COMMUNITY SERVICES DEPARTMENT

May 26, 2021

Subject: Bennet Ranch - Sketch Plan Amendment (SP-203)

BENNET RANCH SKETCH PLAN

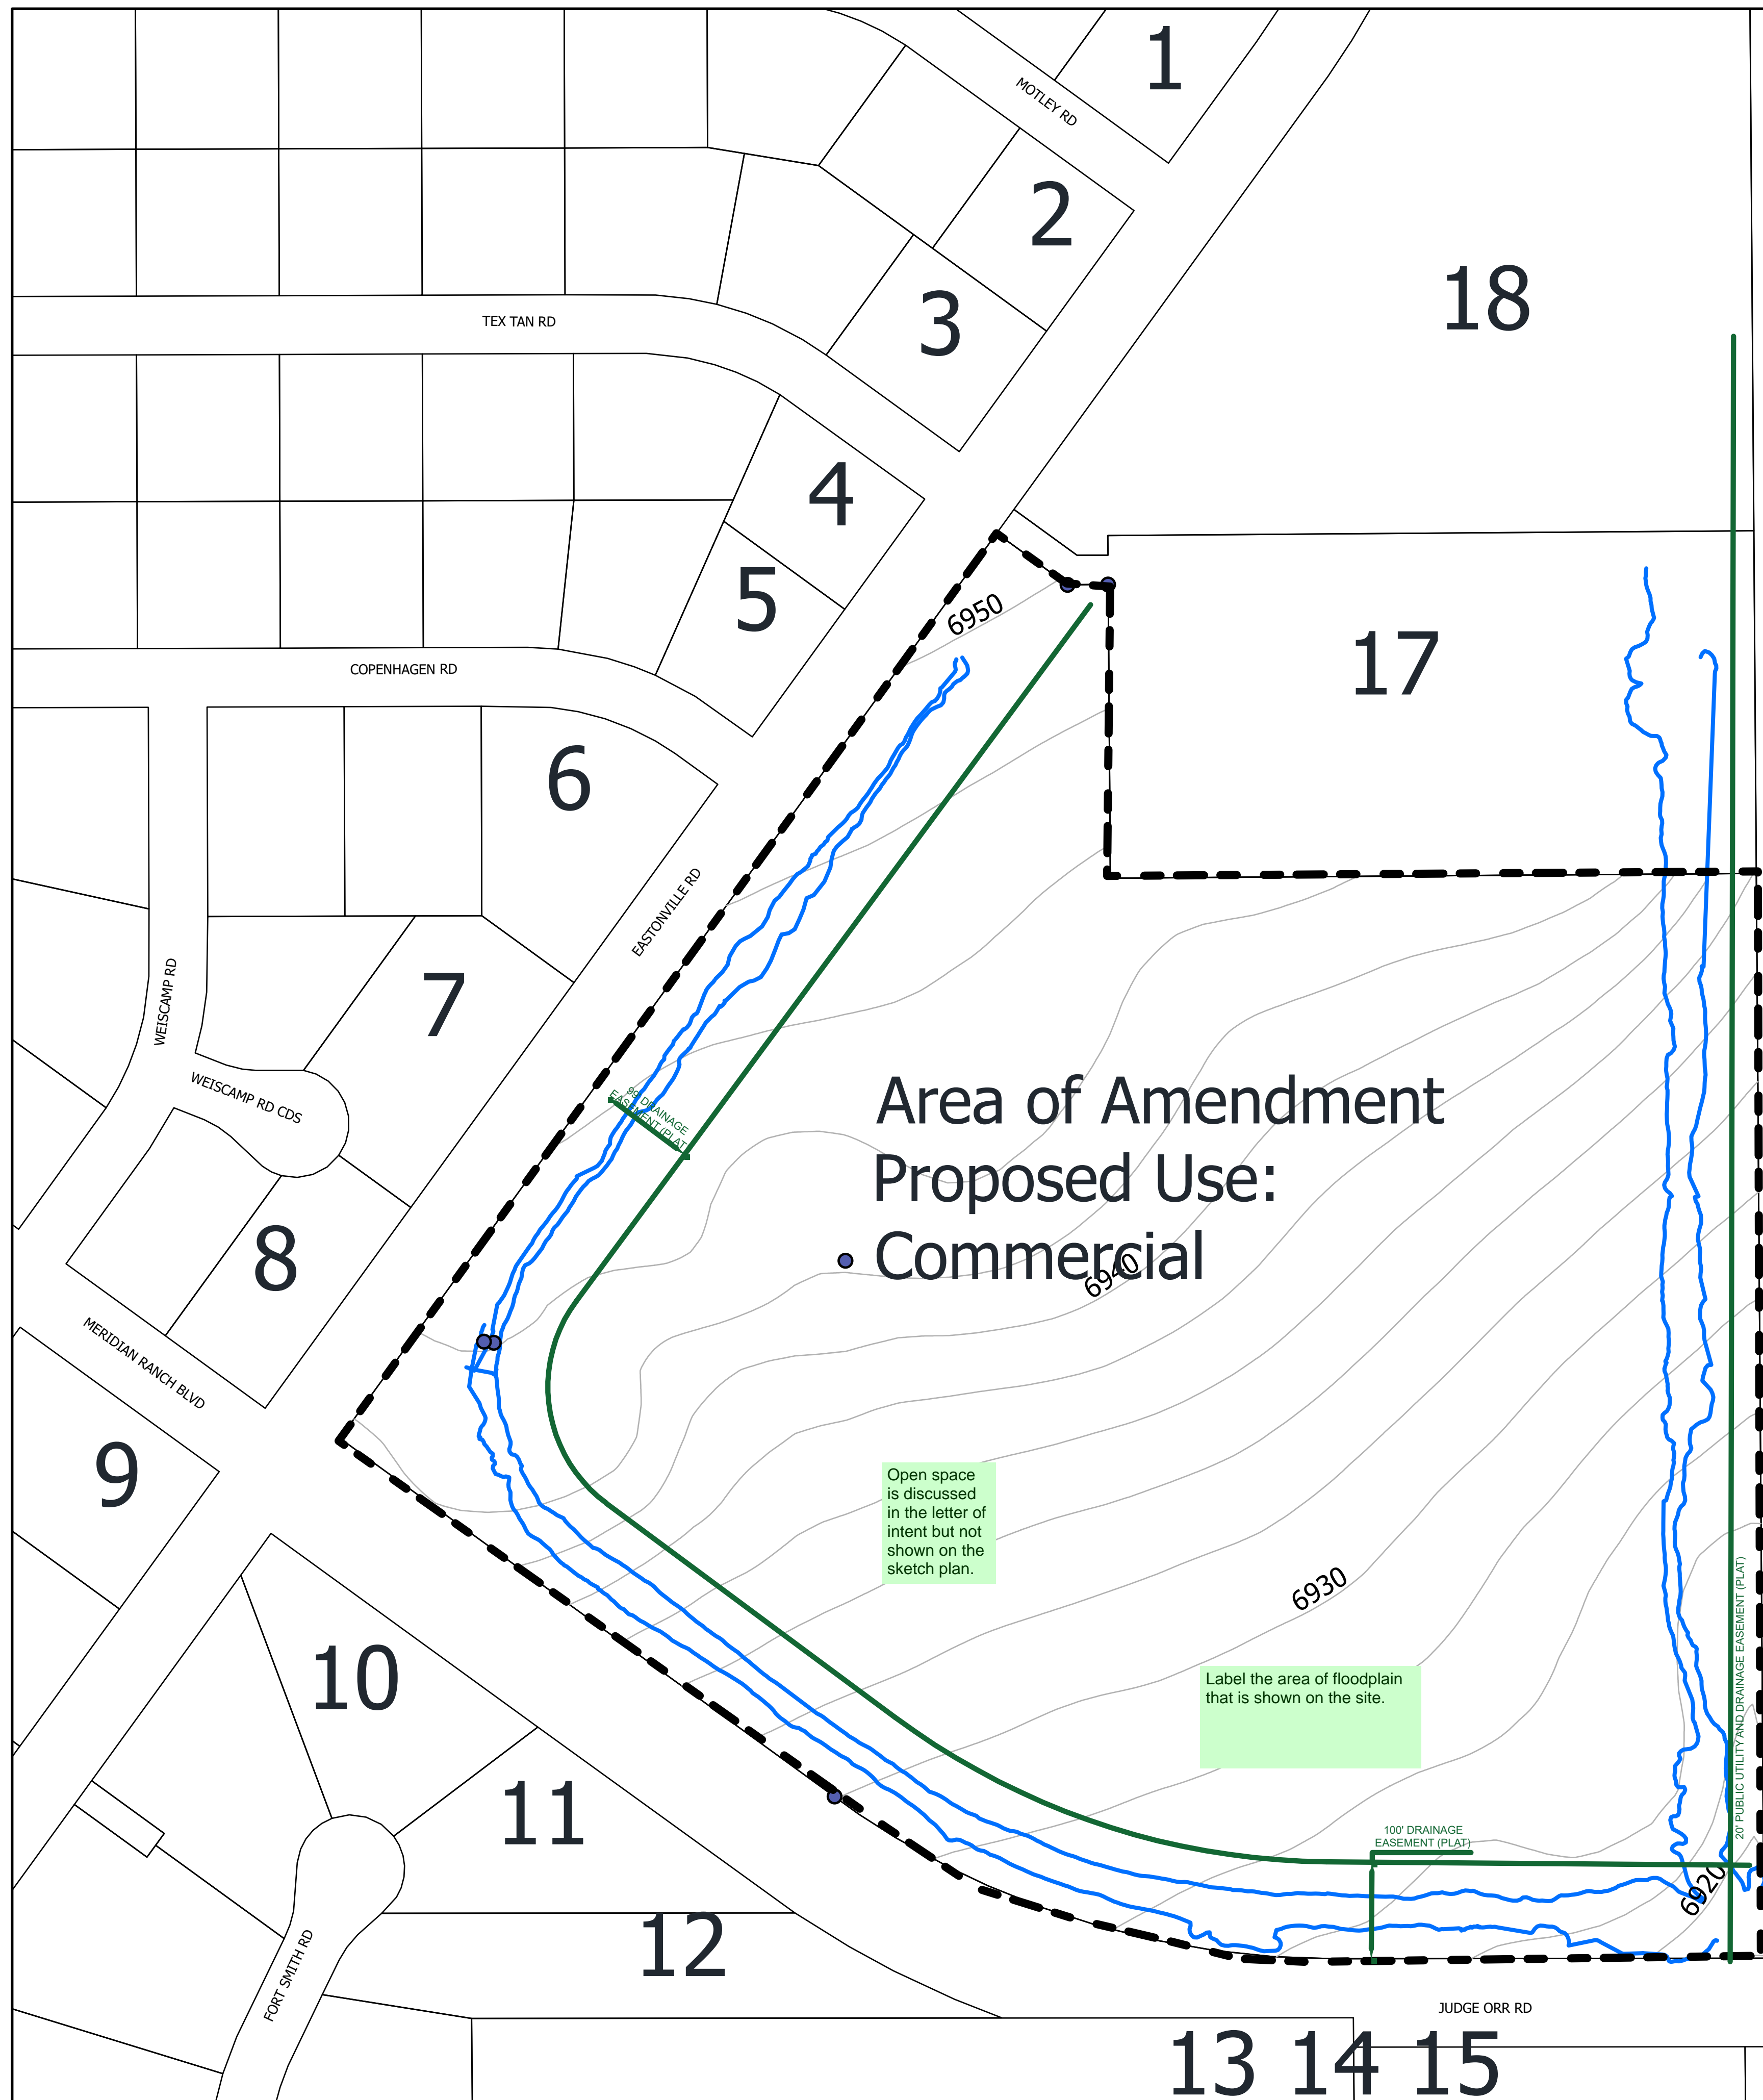
The Park Operations Division of the Community Services Department has reviewed the development application for the Bennett Ranch Sketch Plan Amendment on behalf of El Paso County Parks. Staff acknowledges that deviations have been requested for proposed vehicular access points to the site. These changes do not affect parks or trails. The applicant does still need to show trail dedications as recommended and endorsed by the Park Advisory Board on October 14, 2020:

As it pertains to this application, the County requests that the landowner provide a 25-foot public trail easement along the east side of Eastonville Road that allows for the construction and maintenance by El Paso County of a primary regional trail, and this easement shall be shown and dedicated to El Paso County on the Final Plat. In addition, the County requests that the landowner provide a 25-foot public trail easement along the north side of Judge Orr Road that allows for the construction and maintenance by El Paso County of a secondary regional trail, and this easement shall be shown and dedicated to El Paso County on the Final Plat. Dedications for the aforementioned trails may occur within the existing drainage easements between the public right of way and the wetland boundary.
